From: [Government Relations](#)
To: [Erin White](#)
Cc: [Megan Fu](#); [Government Relations](#)
Subject: CASA Response GI20/512 - Liverpool Hospital Redevelopment (SSD-10389) and Liverpool Hospital Multistorey Car Park (SSD-10388) [SEC=OFFICIAL]
Date: Wednesday, 17 June 2020 10:23:18 AM
Attachments: [image003.png](#)
[image004.png](#)
[image005.png](#)
[image006.png](#)
[image007.png](#)

CASA has reviewed the *Liverpool Health and Academic Precinct Main Works Submission Aviation Flight Path Report*. CASA does not regulate helicopter landing sites and therefore has no issues with Flight Path Report and no objections to the proposed Liverpool Hospital Redevelopment.

PROJECT NO. 21807	DRAWING NO. A-SSDA-MW-16	ISSUE 08
STATUS SSDA AMENDMENT

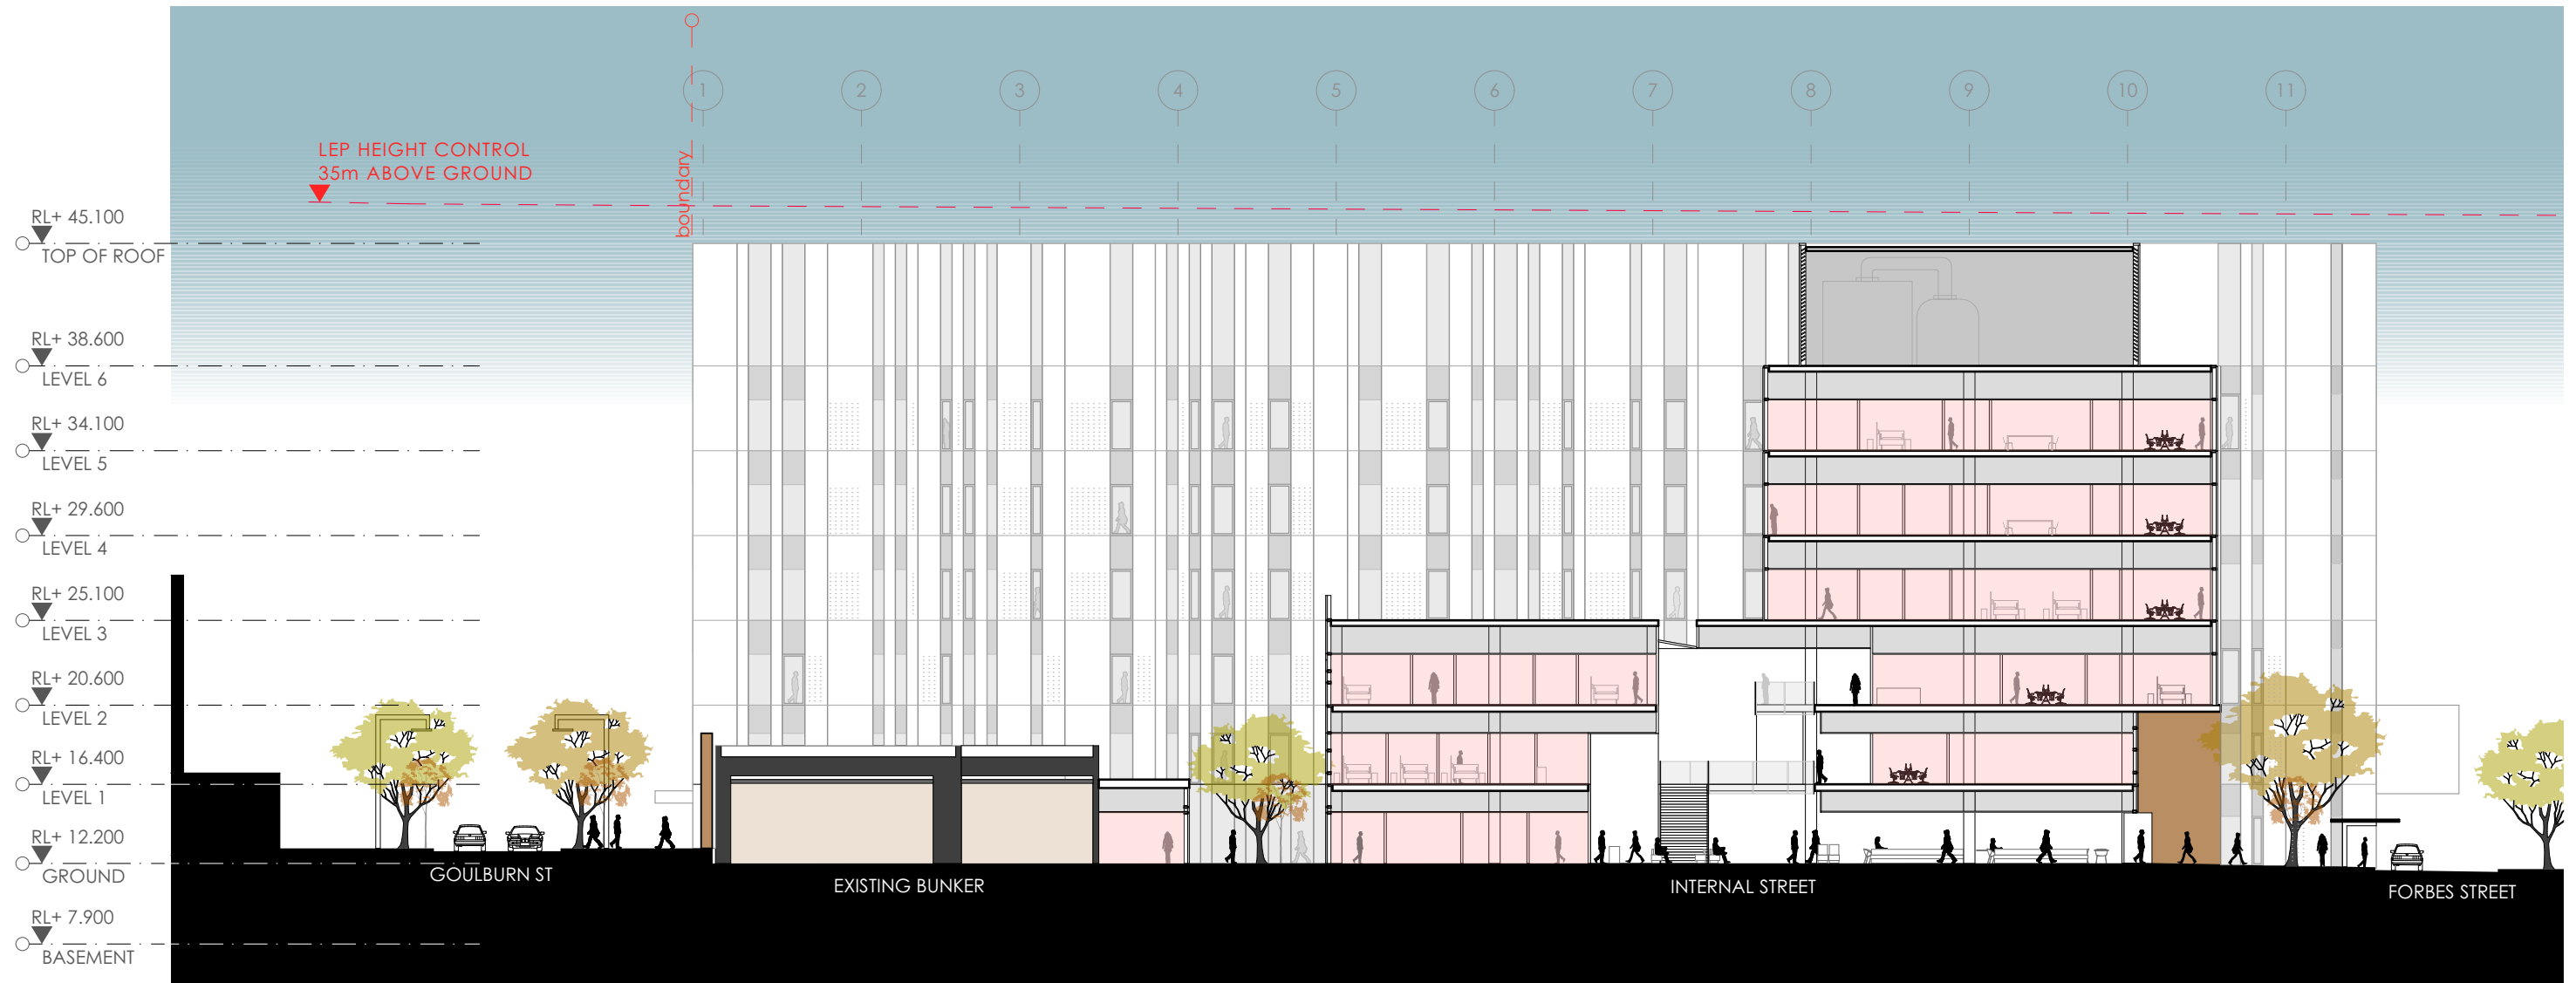
CASA notes there could be a minor discrepancy in the documentation. According to Flight Path Report, the height of the 'LHAP Stage 2' is RL 43.1m. According to the architectural drawings A-SSDA-MW-16/18 of 8 May 2020 and the Environmental Impact Statement, the maximum 'Top of Roof' of the north/south In-patient Unit tower is 45.1m.
